**KIRKLEES COUNCIL  
TOWN AND COUNTRY PLANNING ACT 1990  
HIGHWAYS DEVELOPMENT MANAGEMENT**

**PLANNING REF** 2017/62/93935/E0/MW  
**CATEGORY** Small Major

**PROPOSAL** ERECTION OF 61 DWELLINGS  
WITH ASSOCIATED  
ACCESS, DRAINAGE, OPEN SPACE  
AND LANDSCAPING

**LOCATION** LAND OFF WOODWARD COURT  
MIRFIELD

SITE: Mirfield  
TITLE: Planning Layout  
SCALE AT A1: 1:500 DATE: 17.07.17 DRAWN: TS CHECKED: BS  
PROJECT NO: 1731 DRAWING NO: 1731.01 REVISION: A

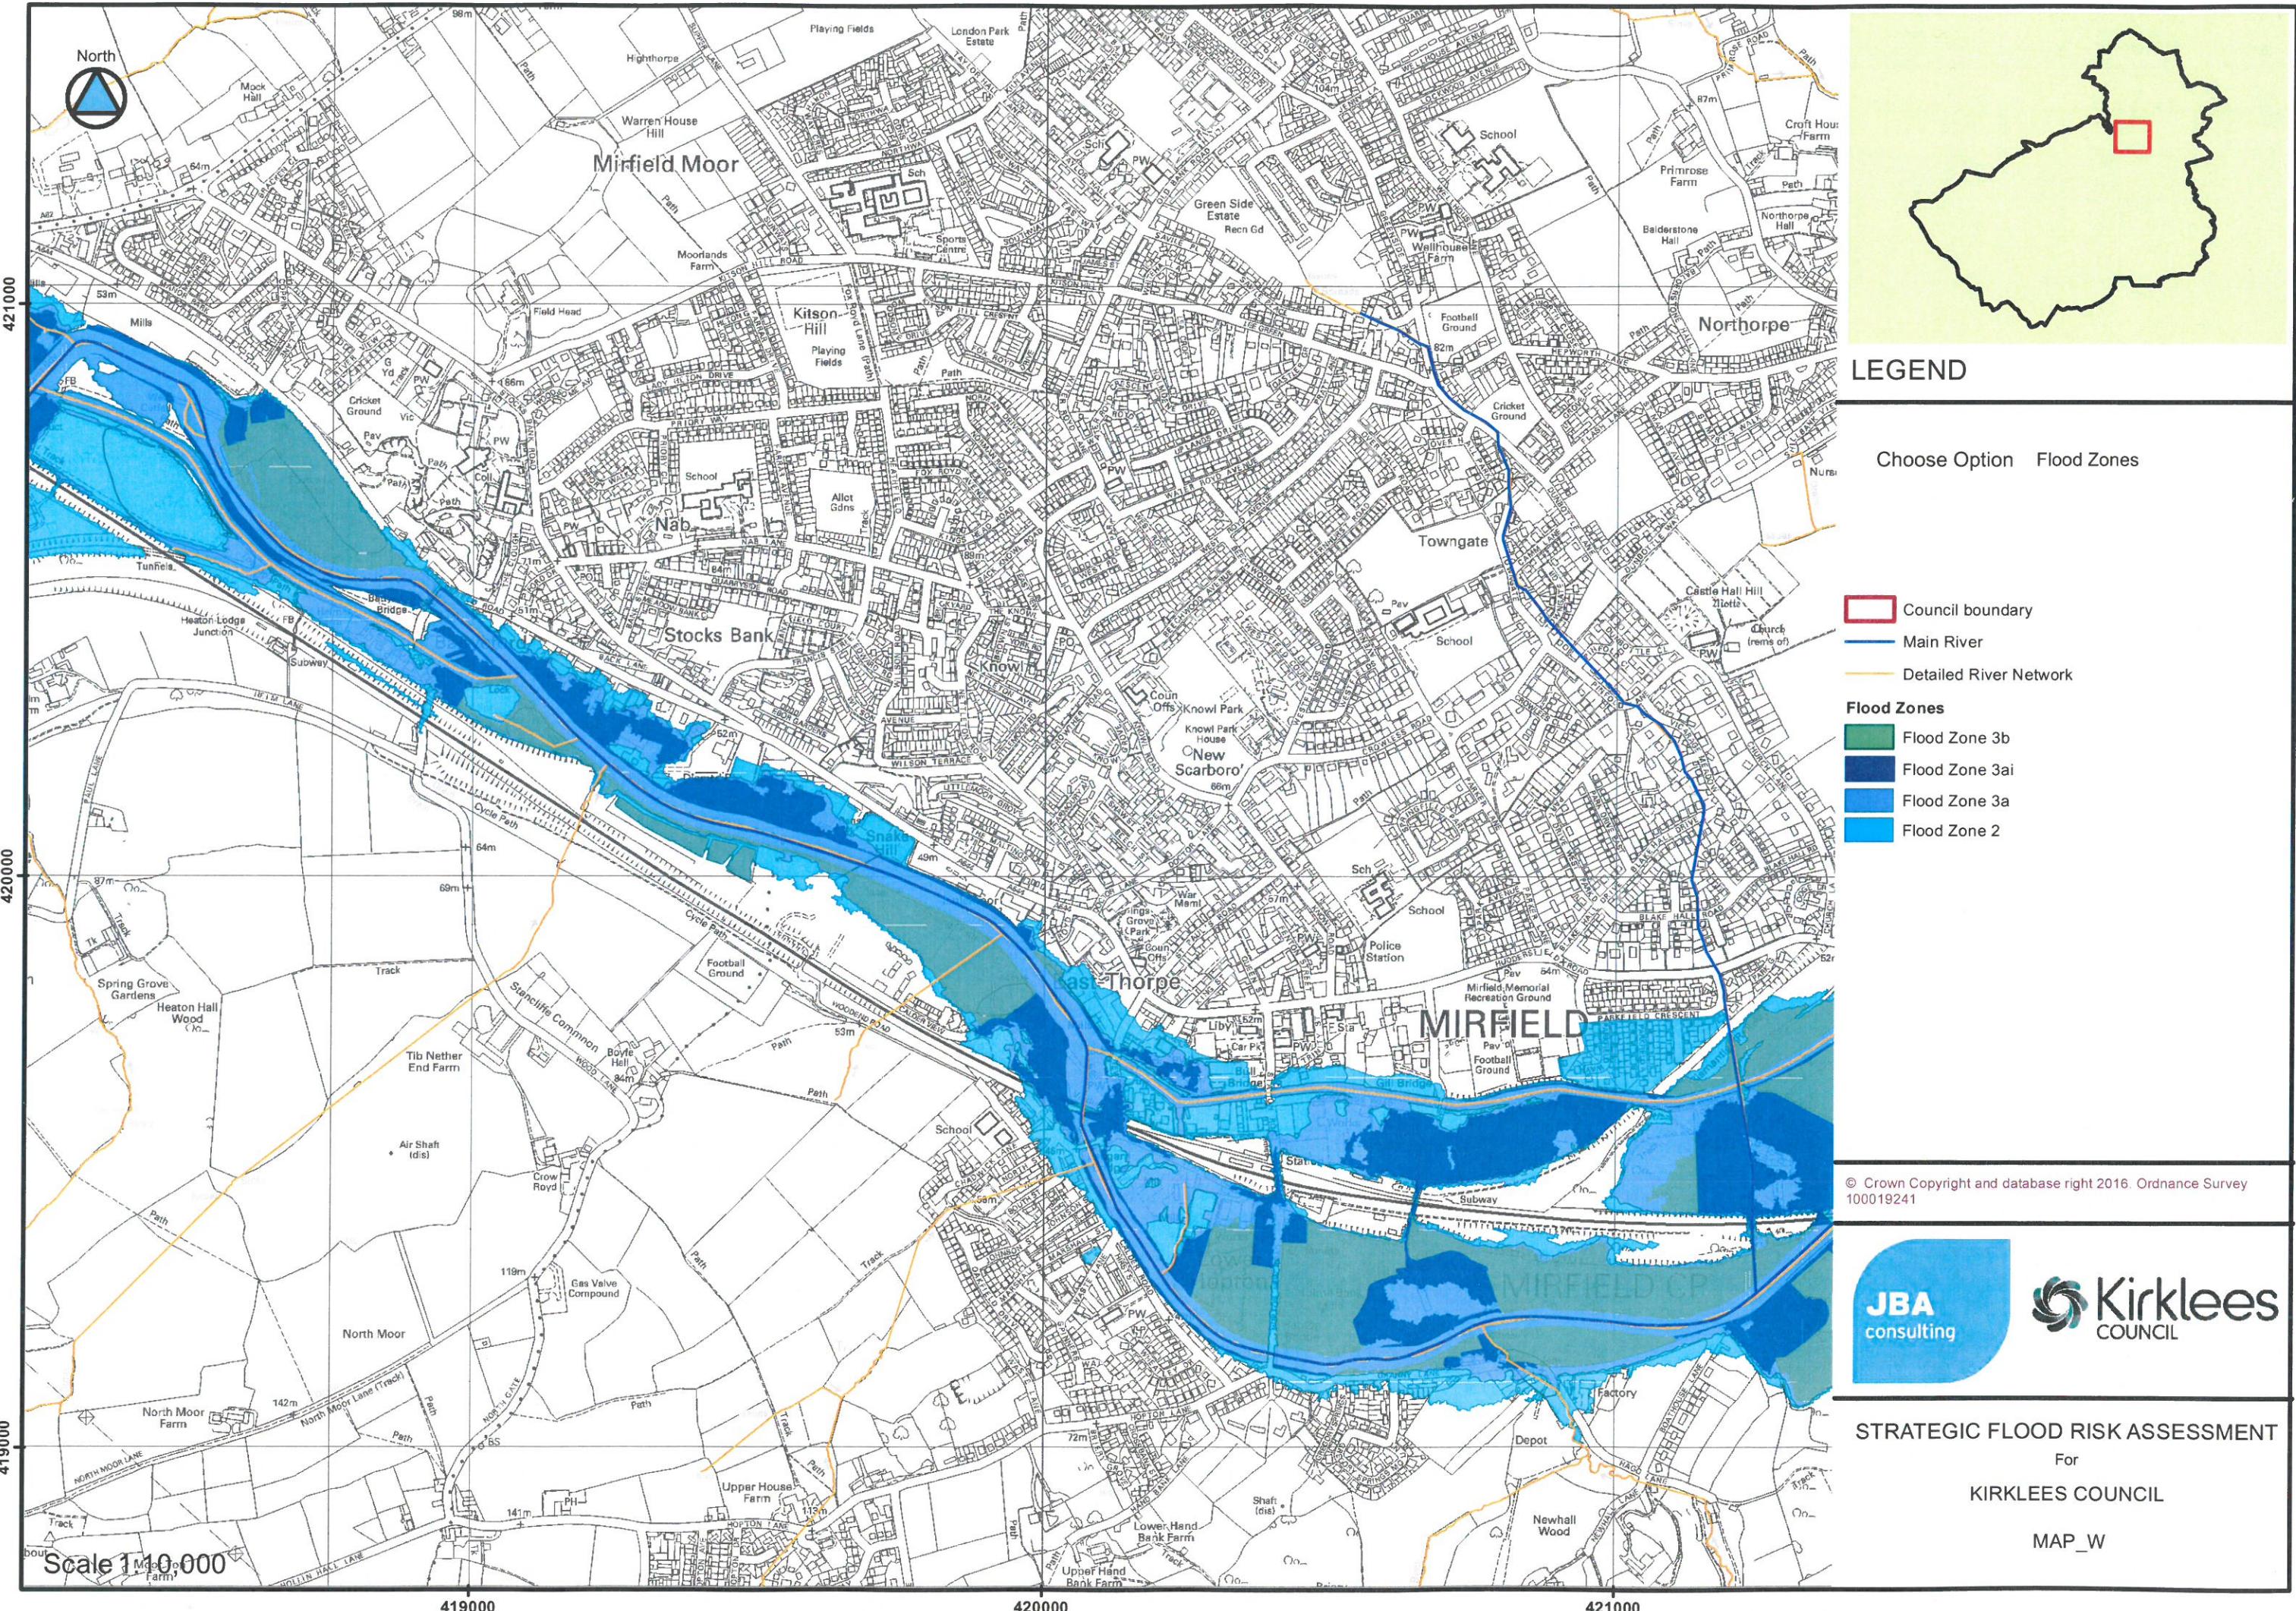
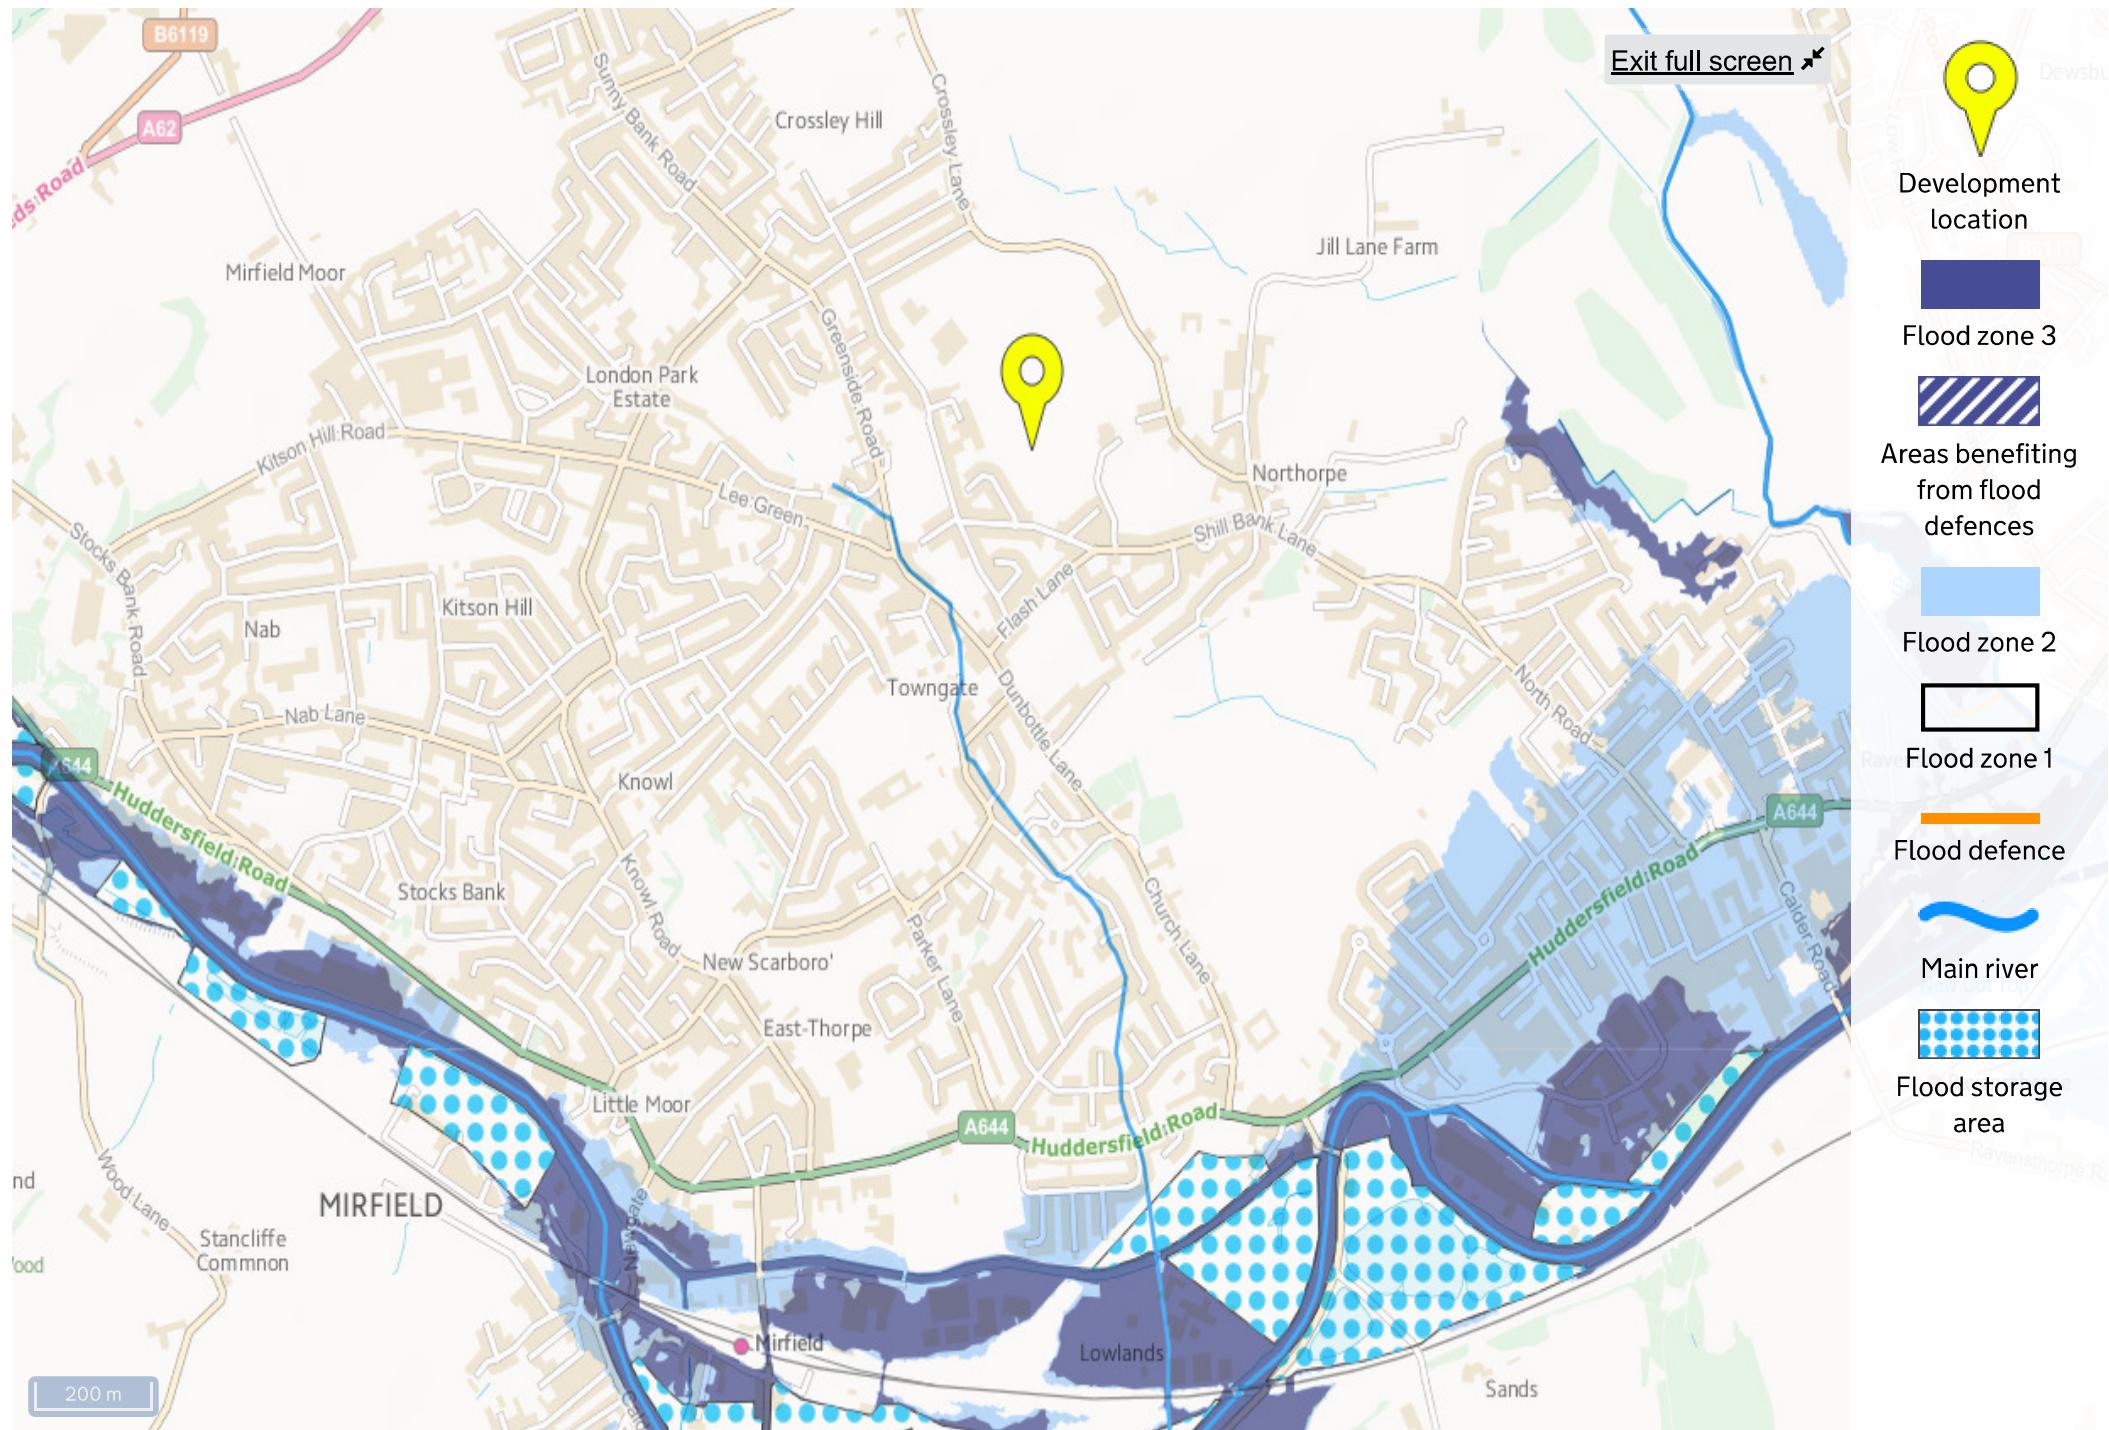
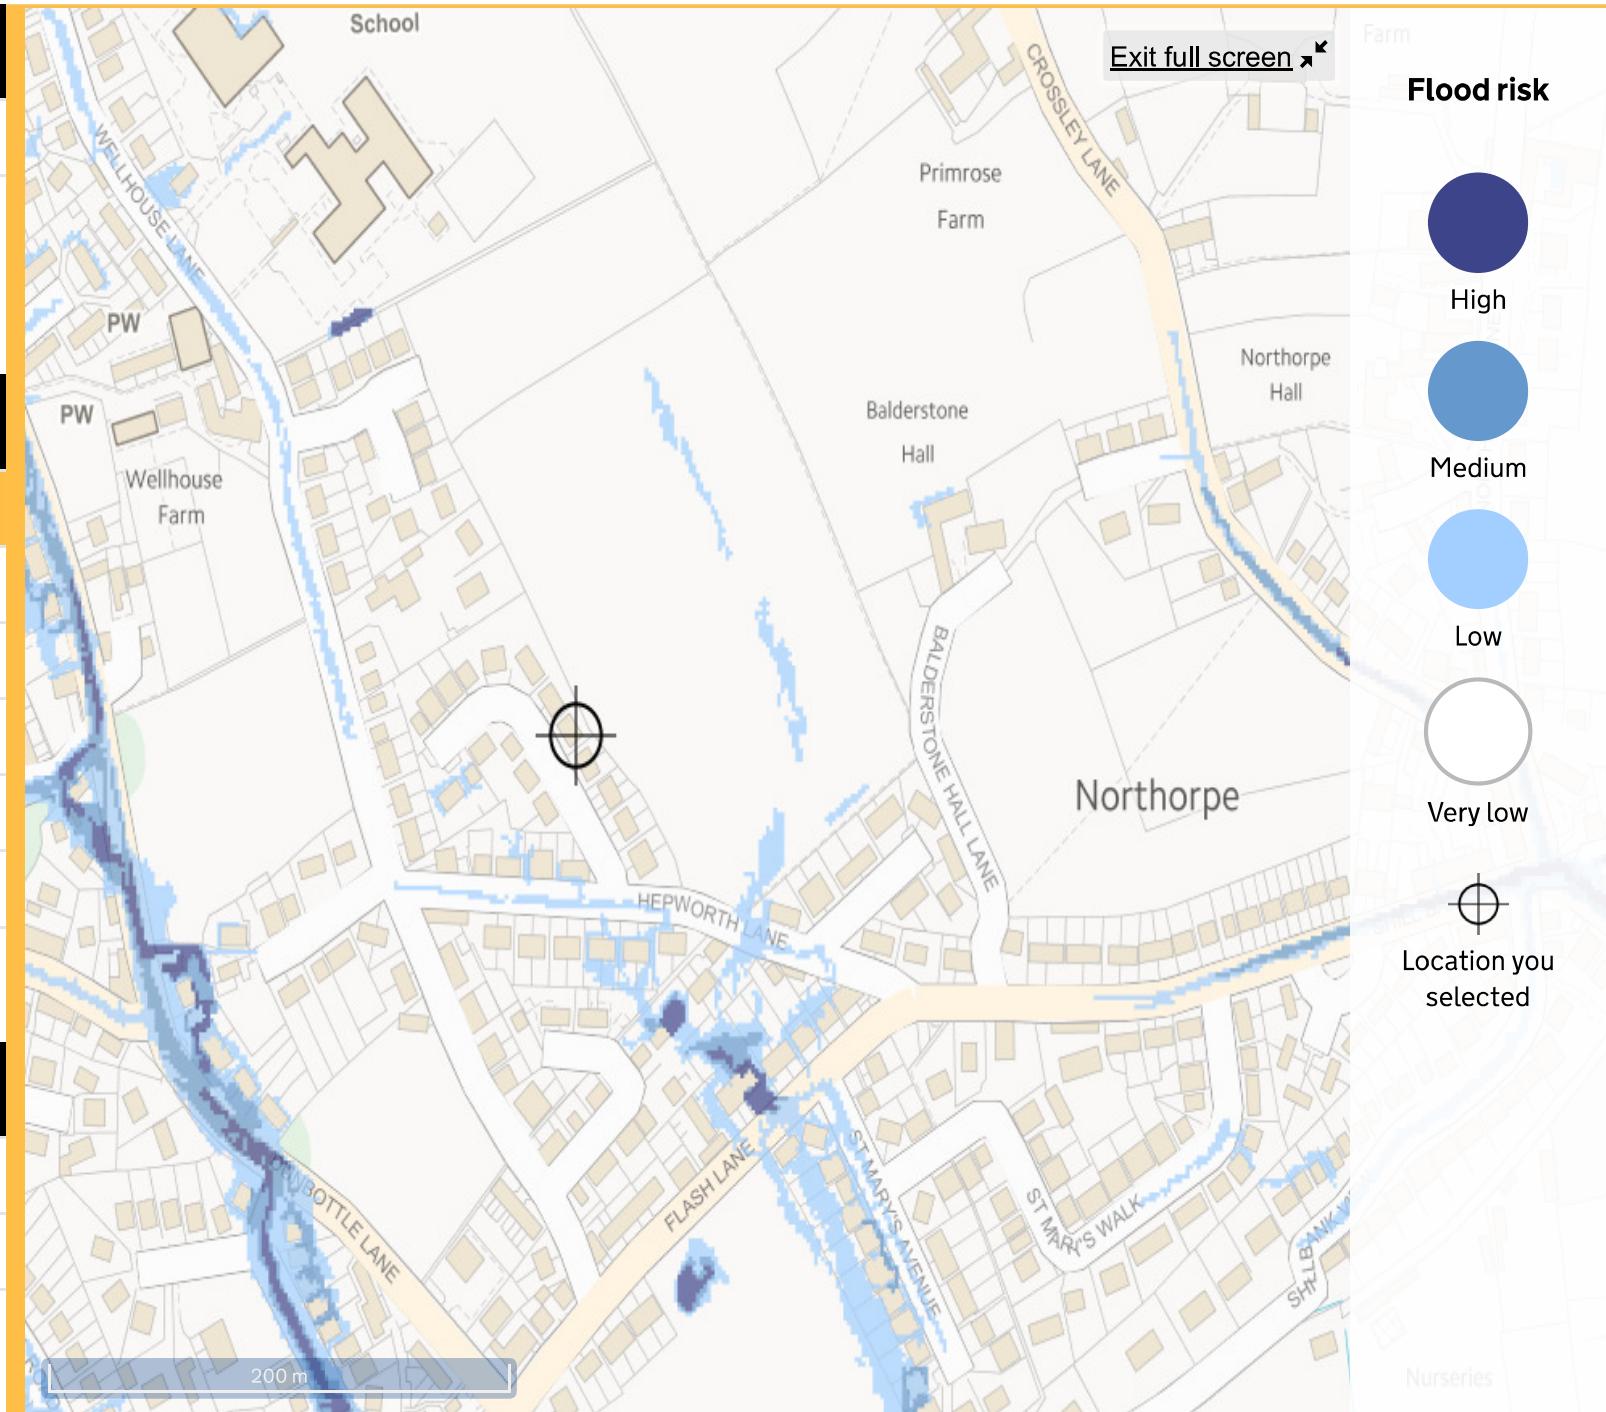
Parking provision, the proposed parking should be in line with the councils parking policy as outlined in the internal layout comments below.

The two turning heads at the north east end of the site should be linked together to form a circular route, this will remove isolation for residents and ensure refuse collection is carried out more efficiently. A plan with vehicle swept paths for refuse collection vehicles 11.85m in length, and two way movements on the spinal roads will also need to be demonstrated.

There is currently no provision for refuse storage within the property boundaries or refuse collection points adjacent to private driveways. Before development commences details of storage and access for collection of wastes from the premises will need to be provided.
